Ann Ronay  
Unit 110  
141-143 McEvoy Street  
Alexandria  
NSW 2015

29 January 2018

**Re: Development Application SSD 8373 – Alexandria Park Community School Redevelopment, Park Road, Alexandria 2015**

SHADOW DIAGRAMS

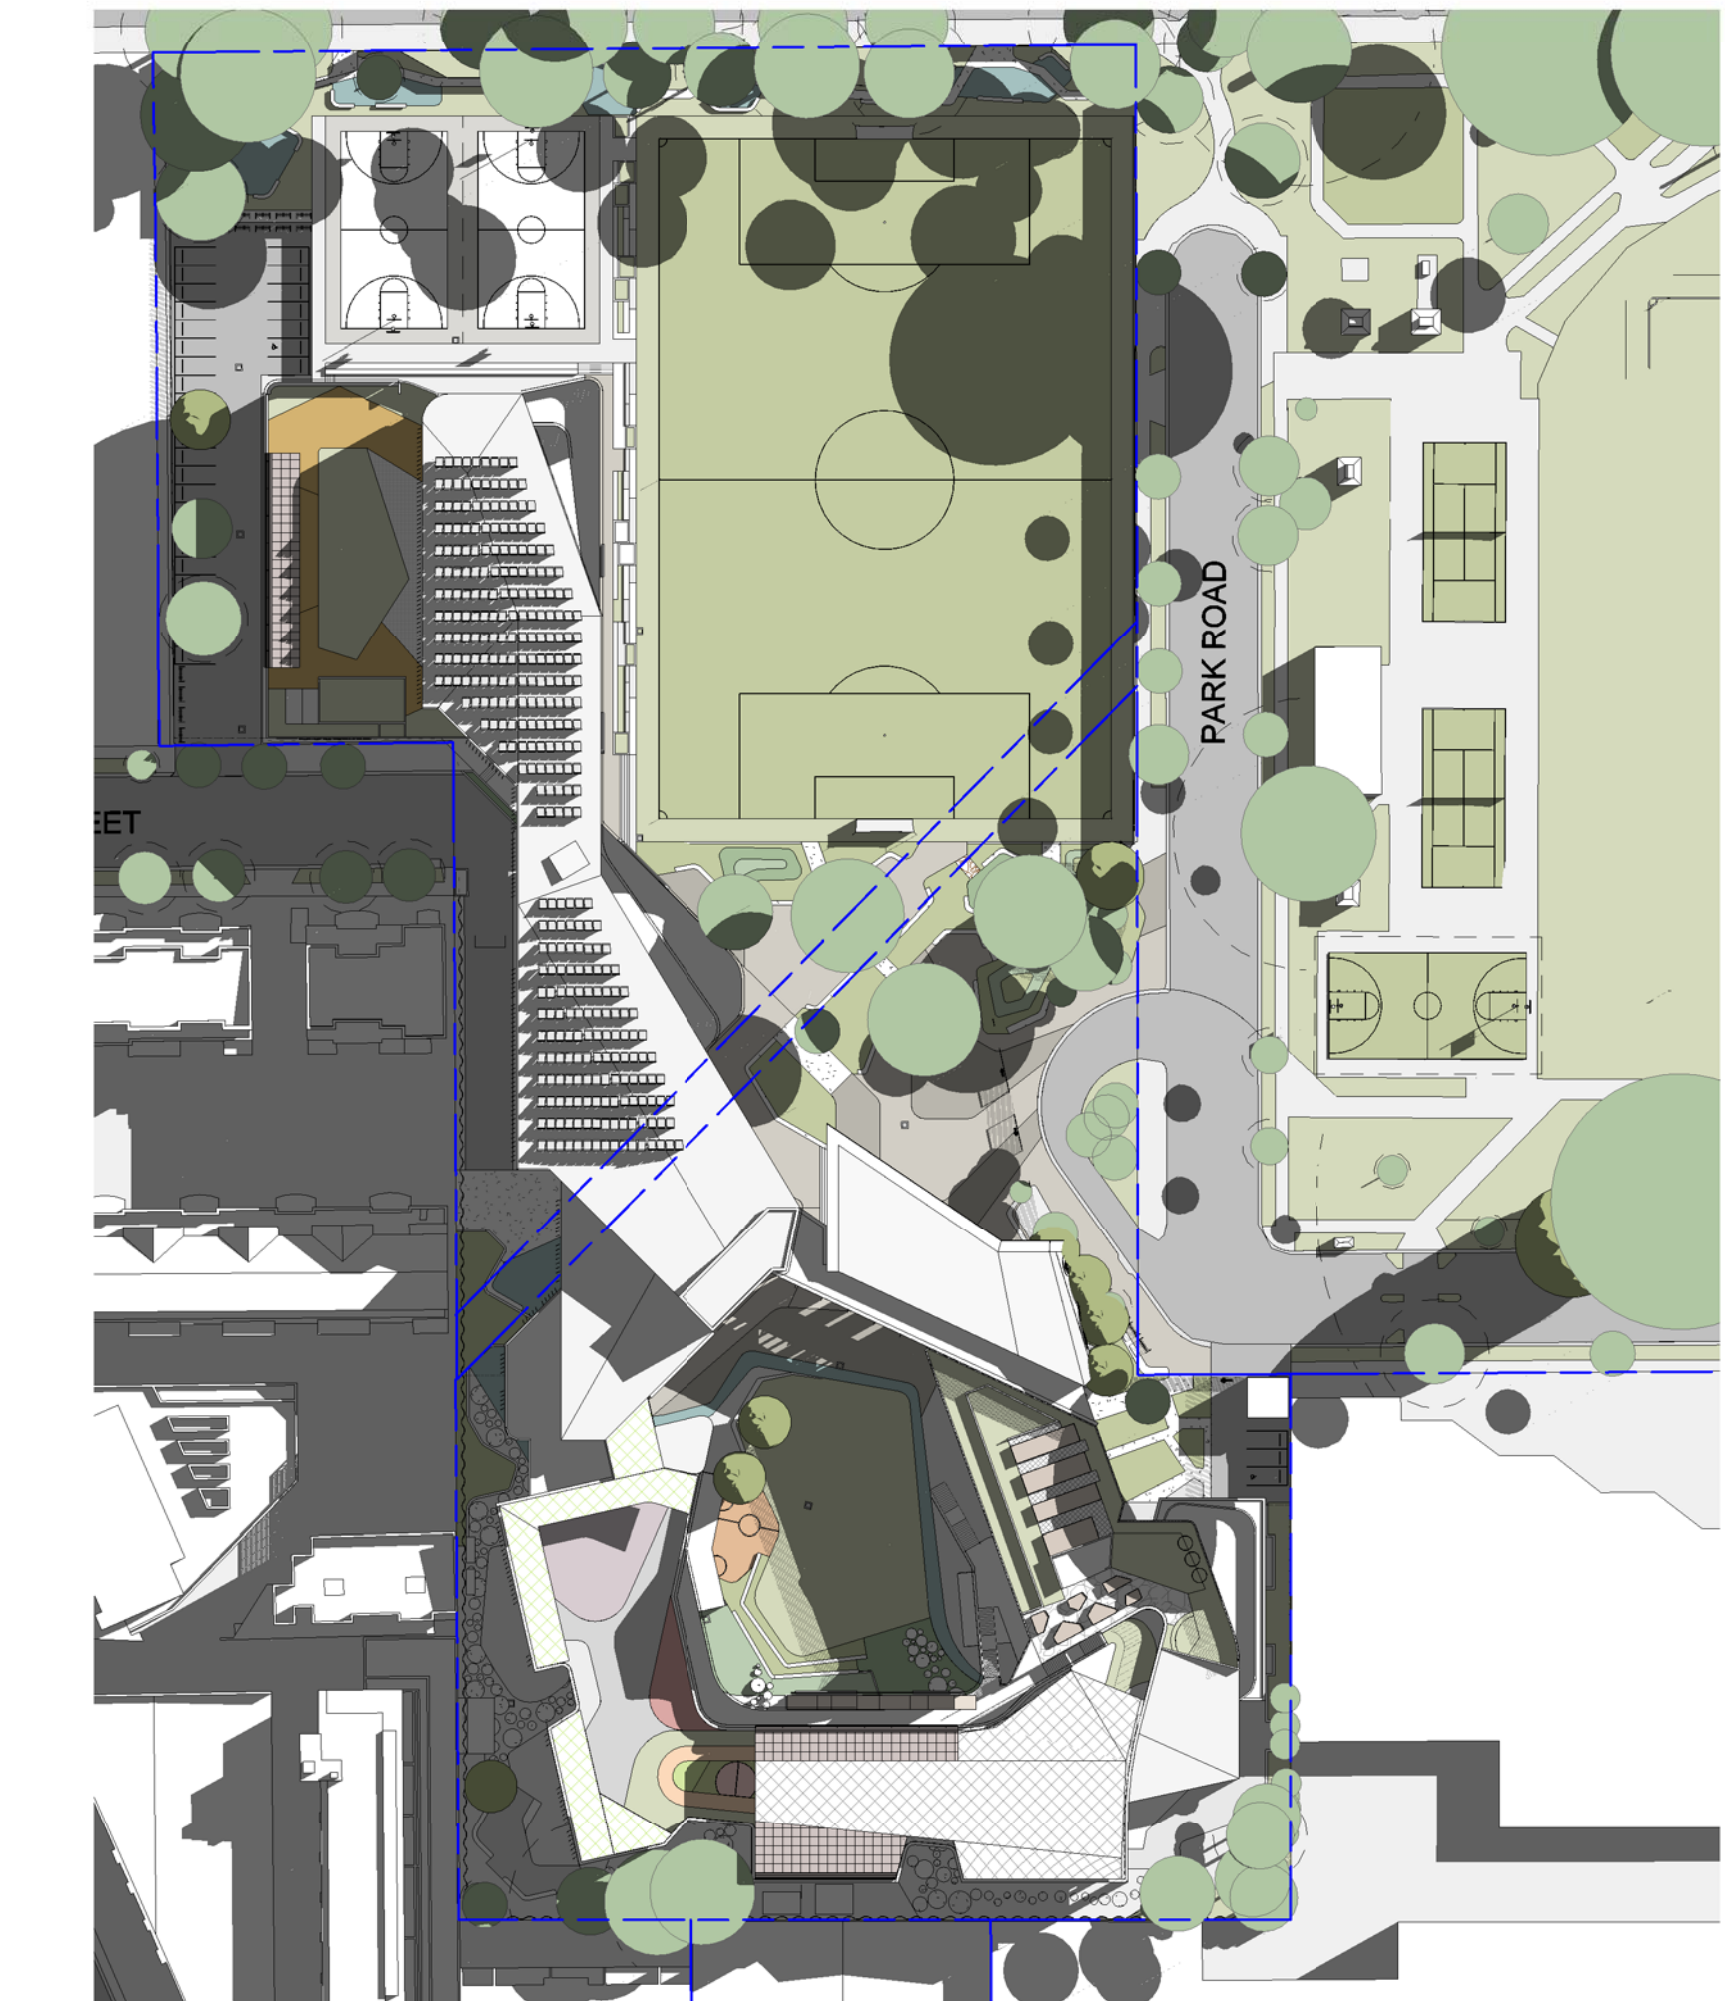
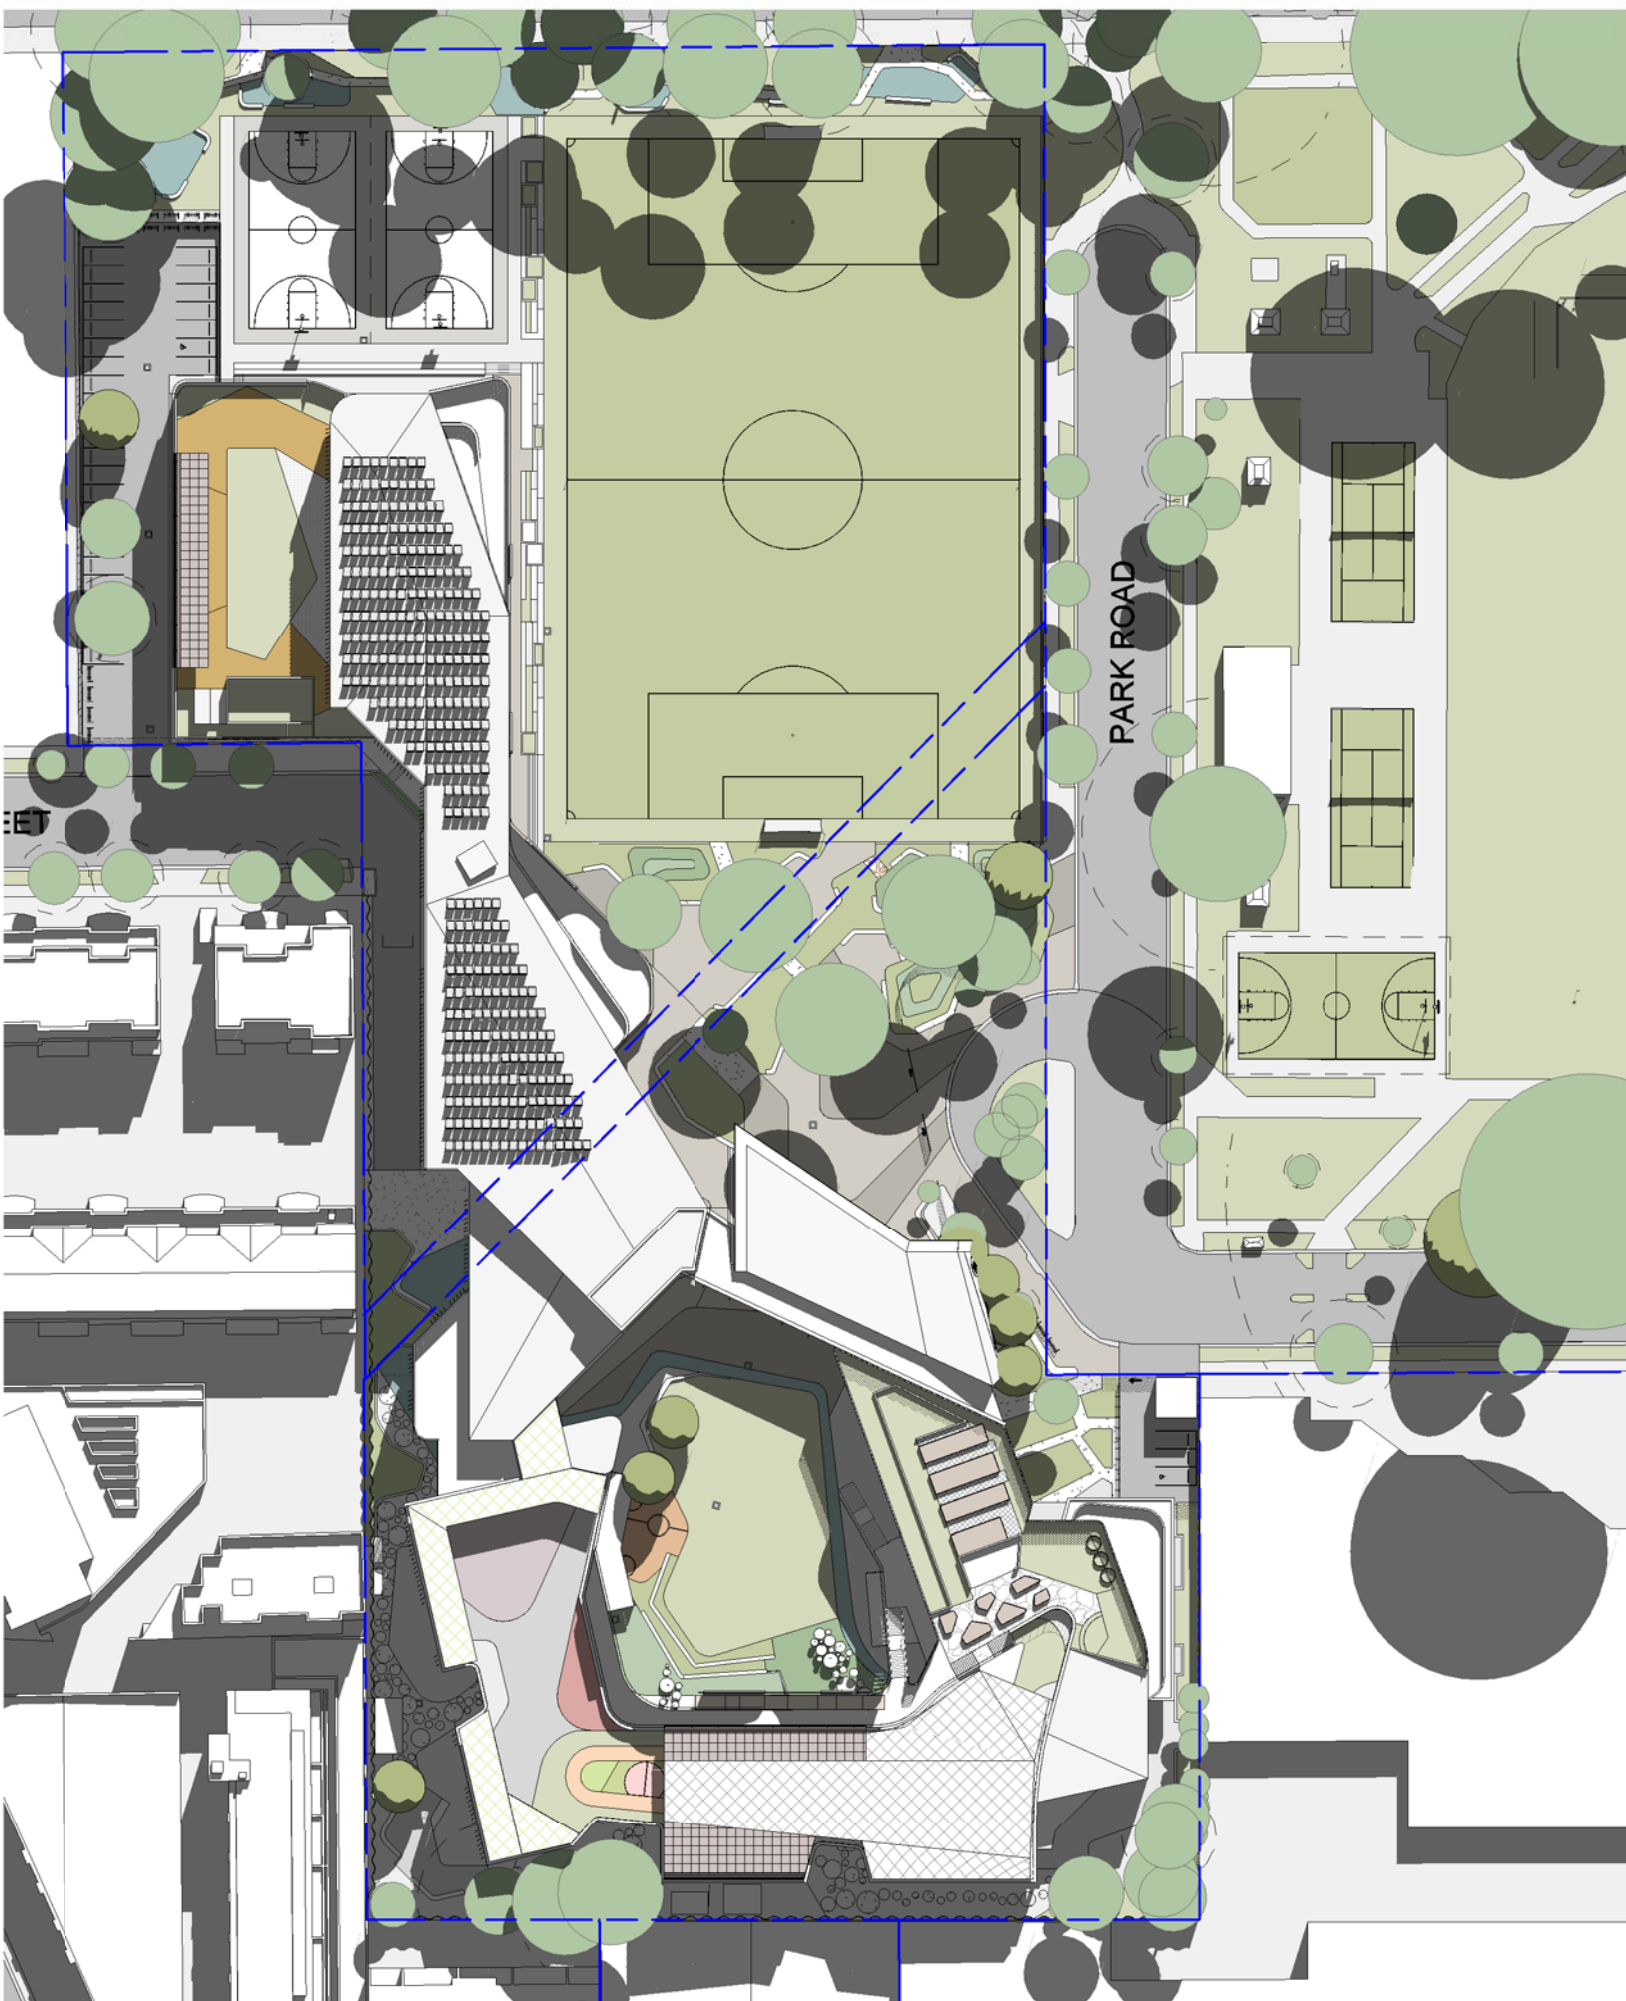
The 15 units in 141-143 McEvoy Street on the southern boundary all have living areas & outdoor areas facing north and the impact on of the overshadowing has not been properly assessed. The documents currently notes the buildings along the south perimeter as commercial which is not correct. There are **no shadow elevational diagrams** at all on Drawing No. AR.DA.5002 P1 for 141-143 McEvoy Street which is a residential property & therefore as my understanding is, is required to be taken into consideration.

The shadow plans show that the southern properties will have all sunlight removed at ground level. Has the lowered level of my property and the 5 adjacent properties been taken into consideration in the assessment?
